STATE OF NORTH CAROLINA
DEPARTMENT OF TRANSPORTATION

SUBJECT: Triangle Expressway Southeast Extension (Complete 540) from NC 55 Bypass in Apex to US 64/264 (I-87) in Knightdale, Wake and Johnston Counties; Federal Aid No. STP-0540(19), STP-0540(20), and STP-0540(21); WBS Nos. 37673.1.TA1, 35516.1.TA1, and 35517.1.TA1; STIP Project Nos. R-2721, R-2828, and R-2829

DEPARTMENT OF THE ARMY
U.S. ARMY CORPS OF ENGINEERS, WILMINGTON DISTRICT
RALEIGH FIELD OFFICE
3331 HERITAGE TRADE DRIVE SUITE 105
WAKE FOREST NC 27587

Reference the Department of the Army permit issued to the North Carolina Turnpike Authority, (NCTA) on October 24, 2019, and subsequently modified, to authorize the discharge of fill material into waters of the United States, for construction of the Triangle Expressway Southeast Extension (Complete 540) from NC 55 Bypass in Apex to US 64/264 (1-87) in Knightdale, Wake and Johnston Counties. Sections included within this permit are R-2721, R-2828, and R-2829.

SITE 15

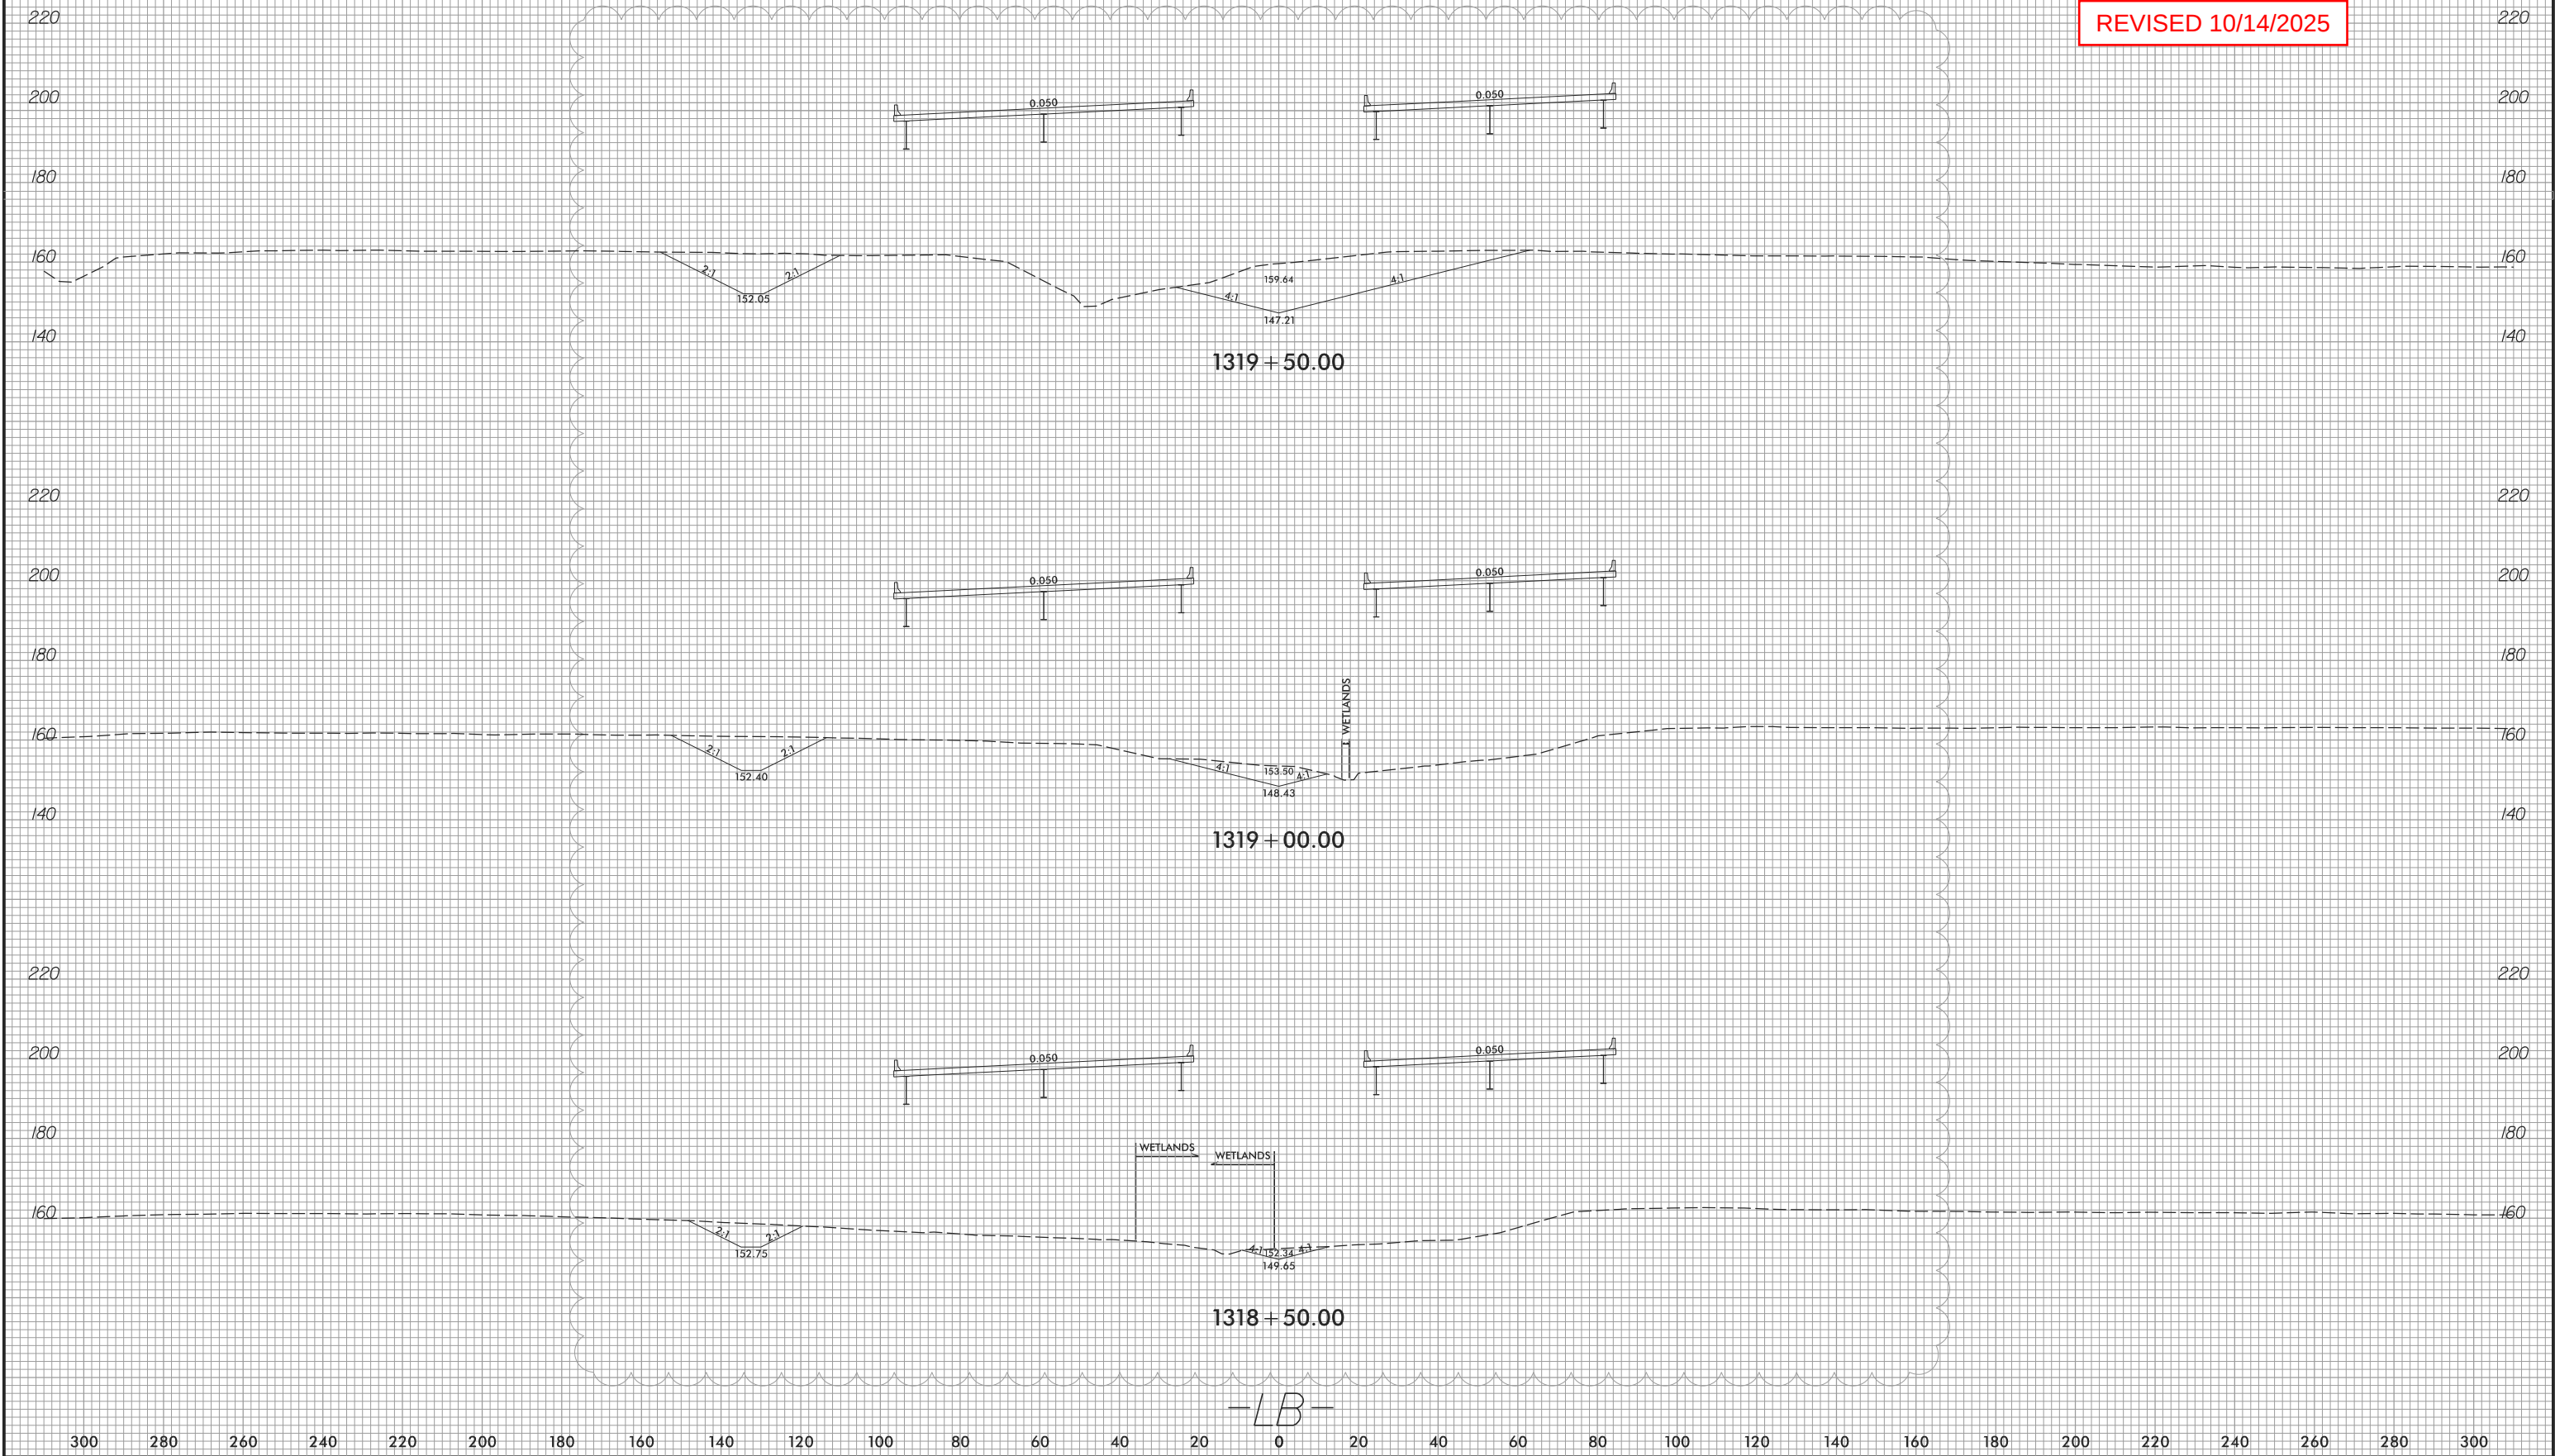
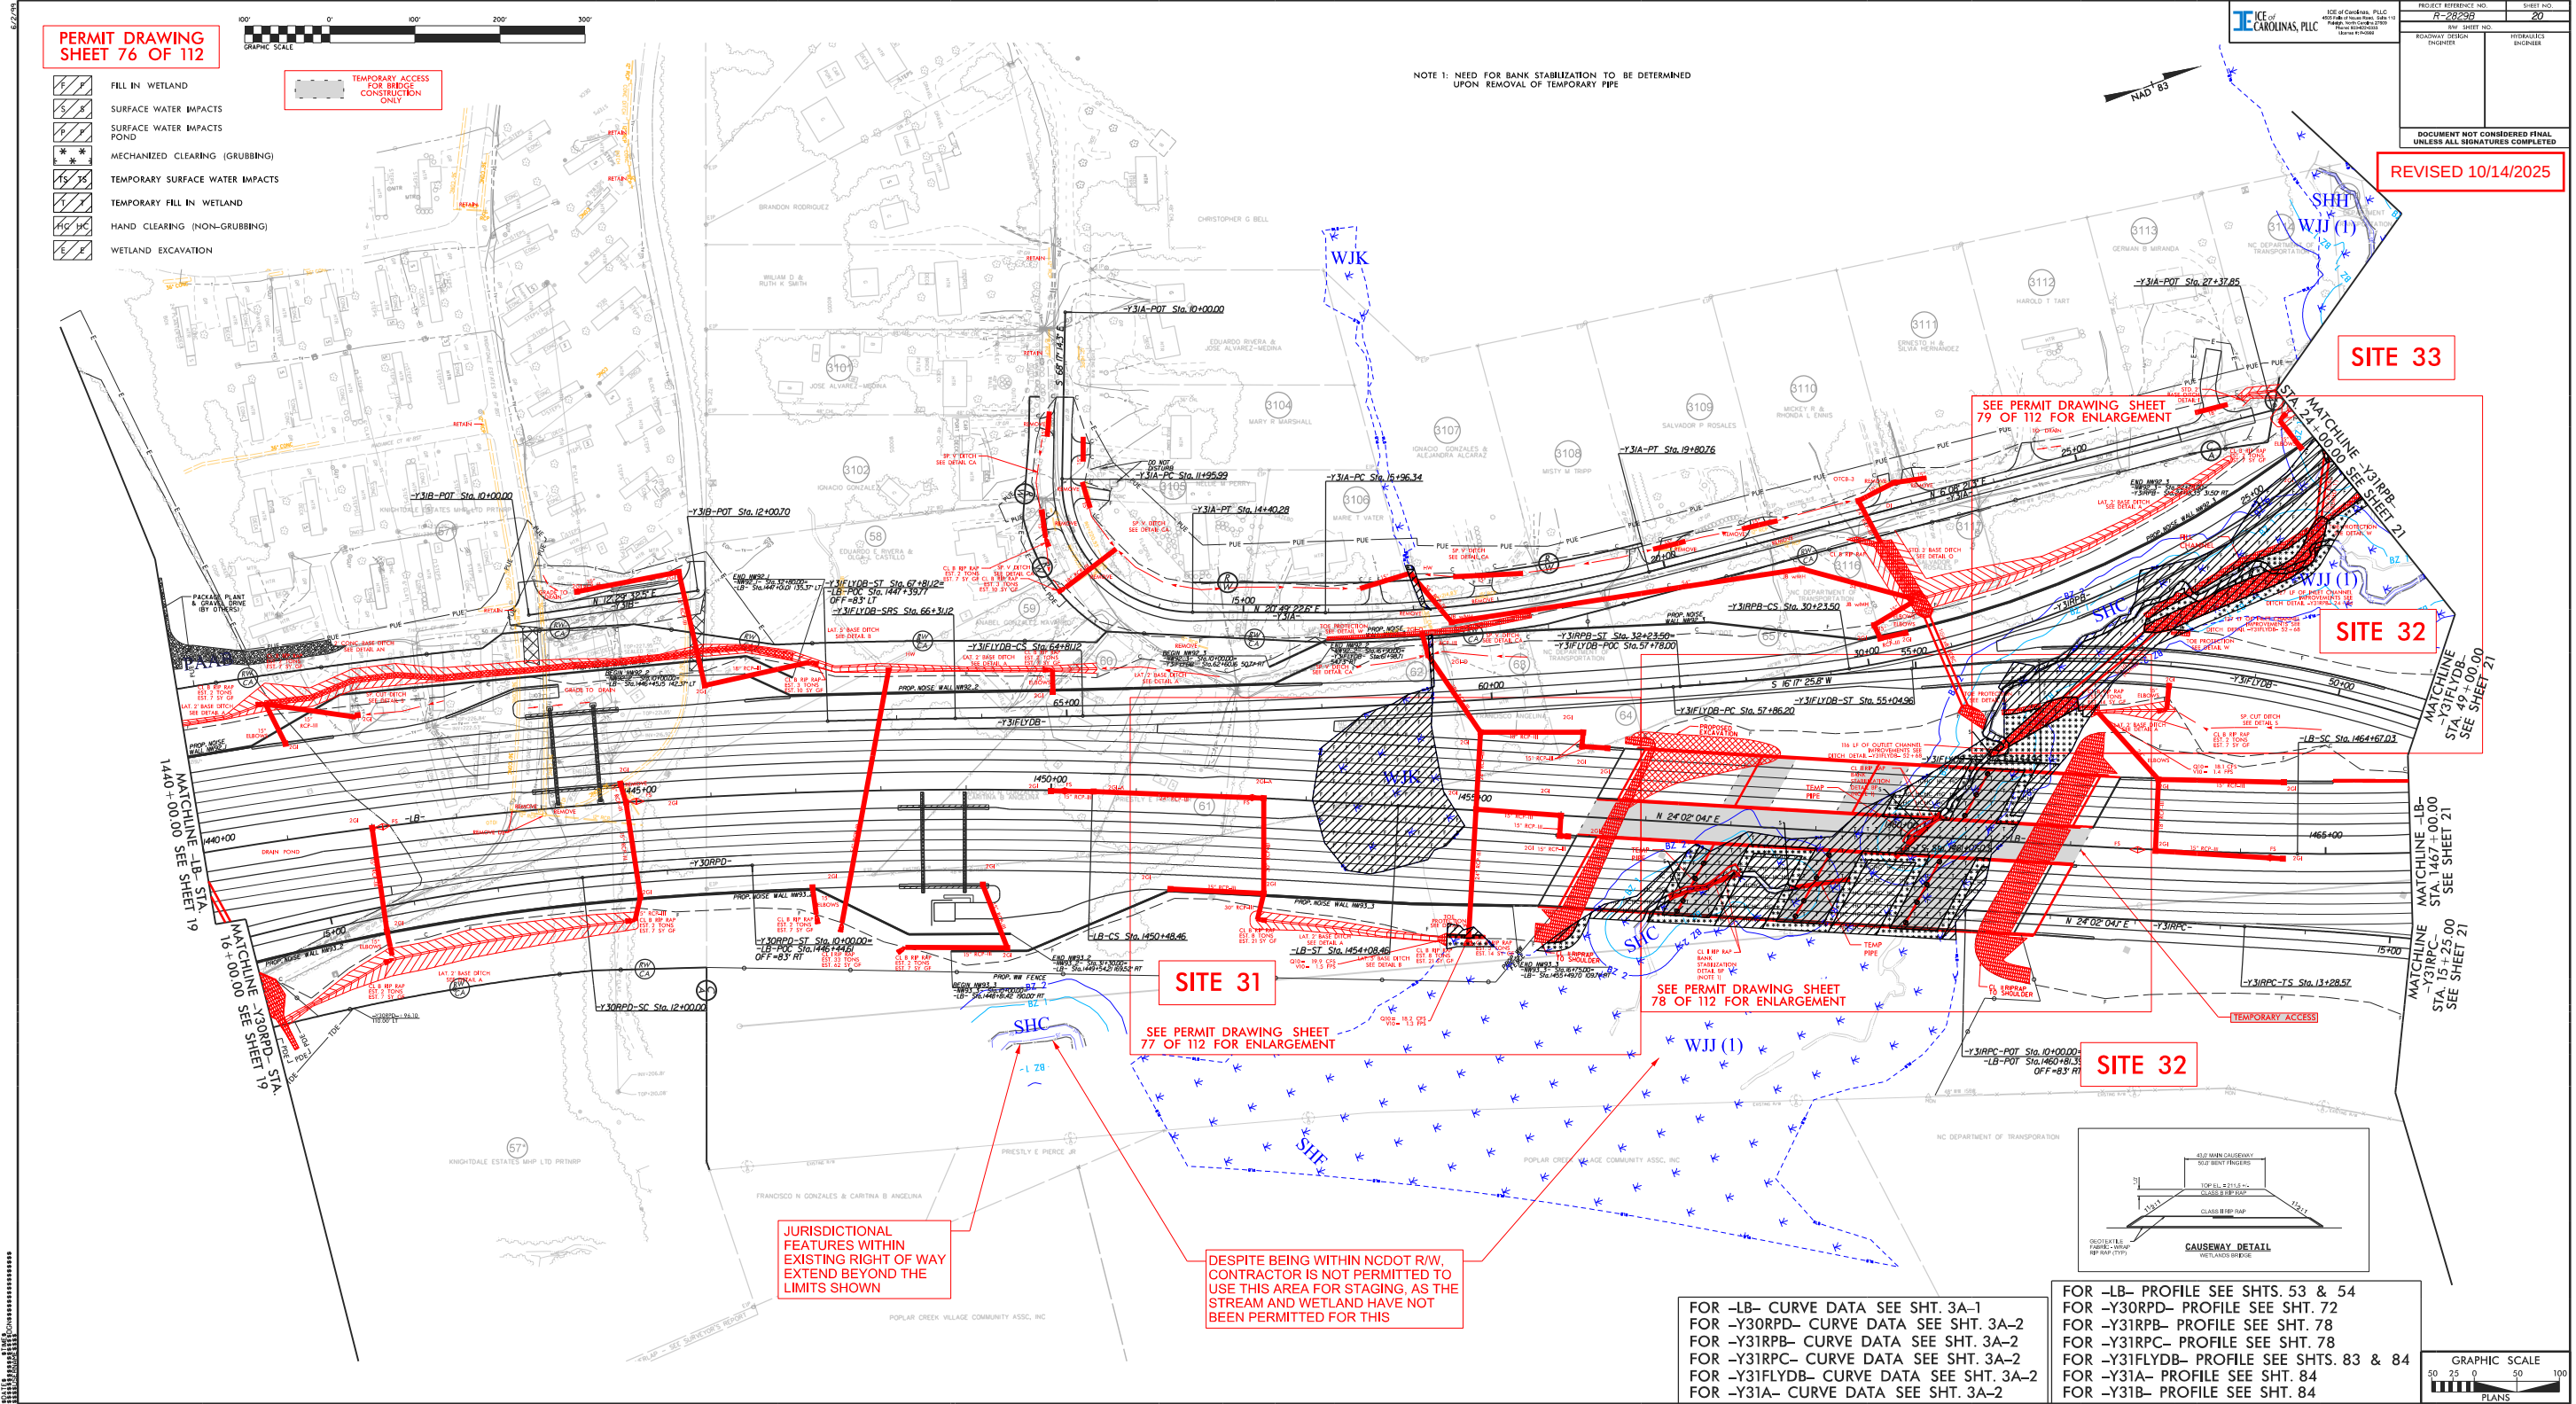
Site 15: Neuse River – Bank stabilization

- Permanent Stream Impact: 51 lf (previously 76 lf - decrease of 25 lf)
- Temporary Stream Impact: 73 lf (previously 108 lf - decrease of 35 lf)
